WEST SUSSEX COUNTY COUNCIL CONSULTATION

TO:	Arun District Council FAO: Amber Willard
FROM:	WSCC - Highways Authority
DATE:	25 March 2022
LOCATION:	Land to the rear of Clare Court, 67 Barnham Road, Eastergate, PO22 0EP
SUBJECT:	BN/16/22/PL Erection of 4 No dwellings with associated car parking. This application is in CIL Zone 2 and is CIL Liable as new dwellings.
DATE OF SITE VISIT:	n/a
RECOMMENDATION:	More Information
S106 CONTRIBUTION TOTAL:	n/a

PROPOSED SITE PLAN . Scale 1:250 at A3

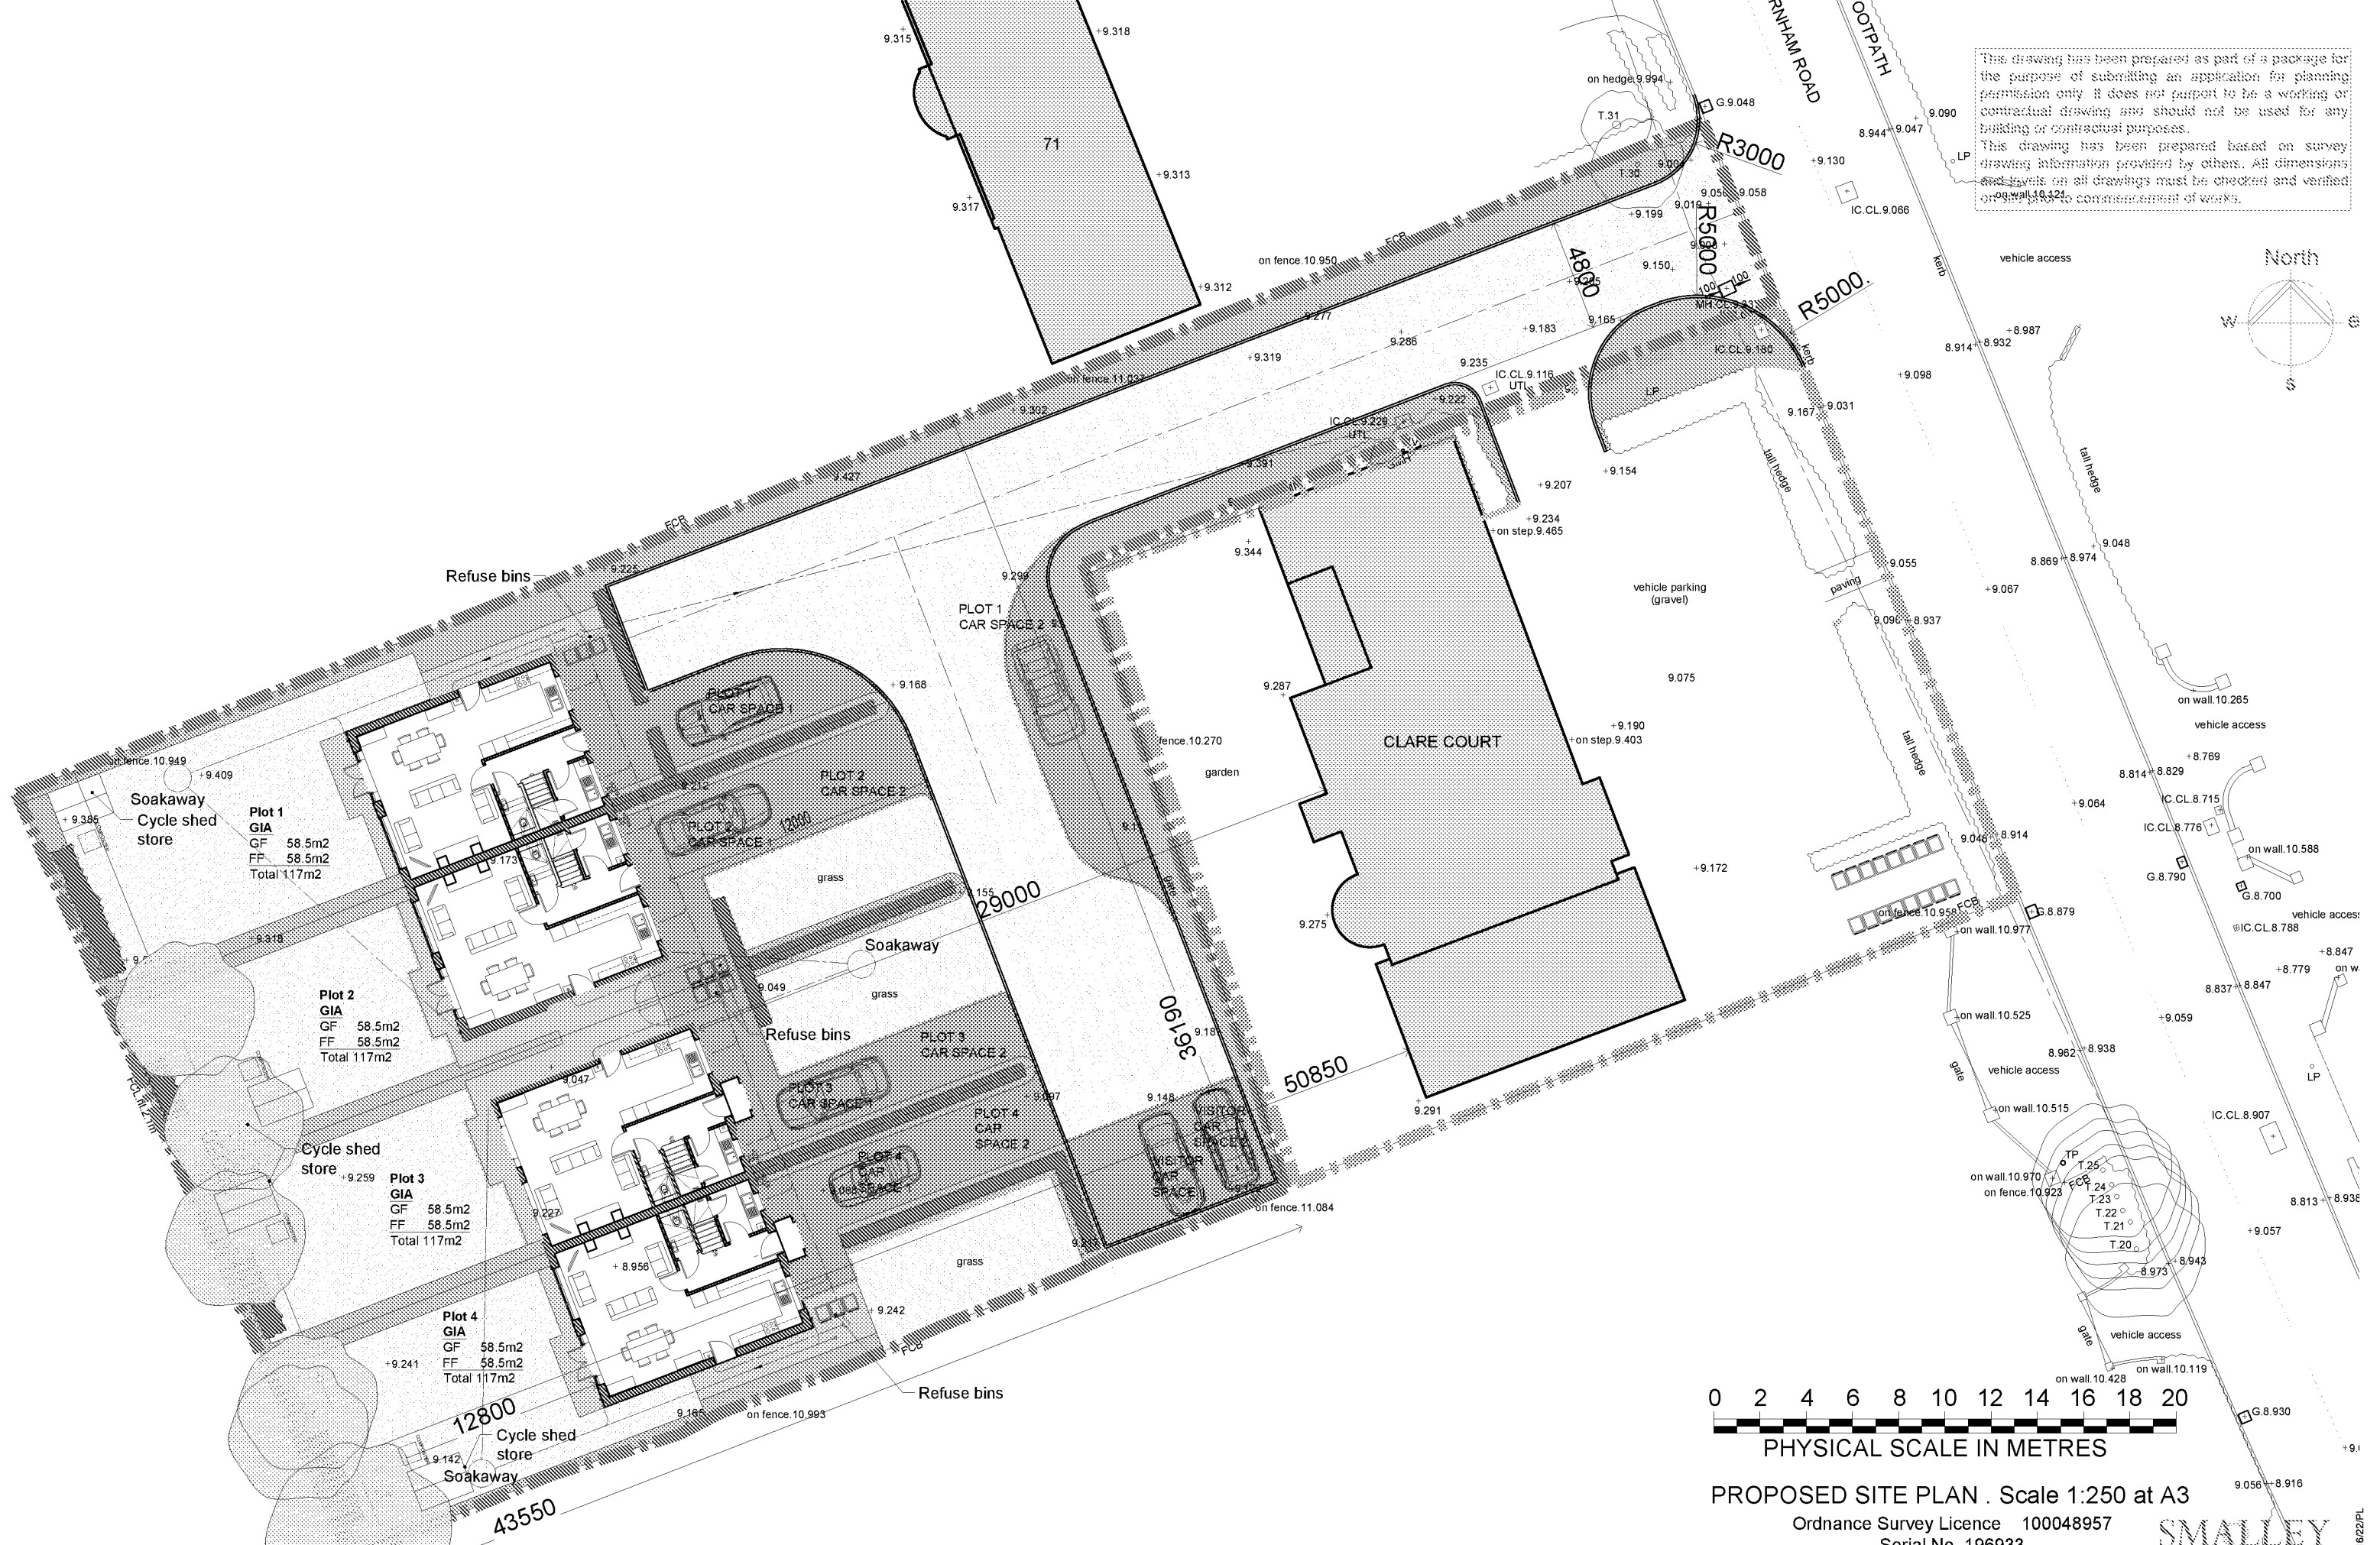
The TS details that the access point will be improved with a bell mouth style construction with a 5m kerb radii south of the access and 3m kerb radii north of the access. Vehicle tracking for a refuse vehicle demonstrates that this geometry would work.

For access points serving this number of dwellings it is typically more appropriate for the access to be a vehicle crossover style rather than a bell mouth set out with kerb radii.

The applicant may wish to consider this modification. Suitable tracking would be required to demonstrate the width of any proposed vehicle crossover would work. A vehicle crossover style access would be more in keeping with neighbouring access points.

Visibility splays of 2.4 x 43 metres have been demonstrated at the site access point. To the south the splay is contained within the extent of the public highway or under land under control of the applicant. To the north it has been identified that the splay crossed 3rd party land.

It is noted that this northern splay has been plotted to the nearside carriageway edge. Can an improvement in visibility be achieved if this is plotted to the edge of a vehicles track? Typically, this would be a 1m offset from the nearside carriageway edge.

Given these limitations with visibility has the applicant investigated if the shared access arrangements can be relocated more centrally within the frontage? Would this provide the opportunity to secure recognised visibility standards in perpetuity, not only for the new dwellings but also the other vehicles currently associated with Clare Court?

No dedicated provision has been made to provide a formalised pedestrian link to the existing pedestrian facilities which are located on the opposing side of Barnham Road. There are no formalised pedestrian crossing facilities serving the site as existing. An informal pedestrian crossing point does exist that serves the wider Clare Court, but it is not provided with dropped crossing points or tactile paving.

It seems this application does provide the opportunity to improve upon pedestrian access facilities to the site. This could be by improving the existing informal arrangement by way of dropped crossings on either side of Barnham Road, paired with tactile paving or designing pedestrian access into the vehicle access improvements. This would support National Planning Policy Framework policies 110 a & b. If this was taken up these should be demonstrated with suitable visibility splays.
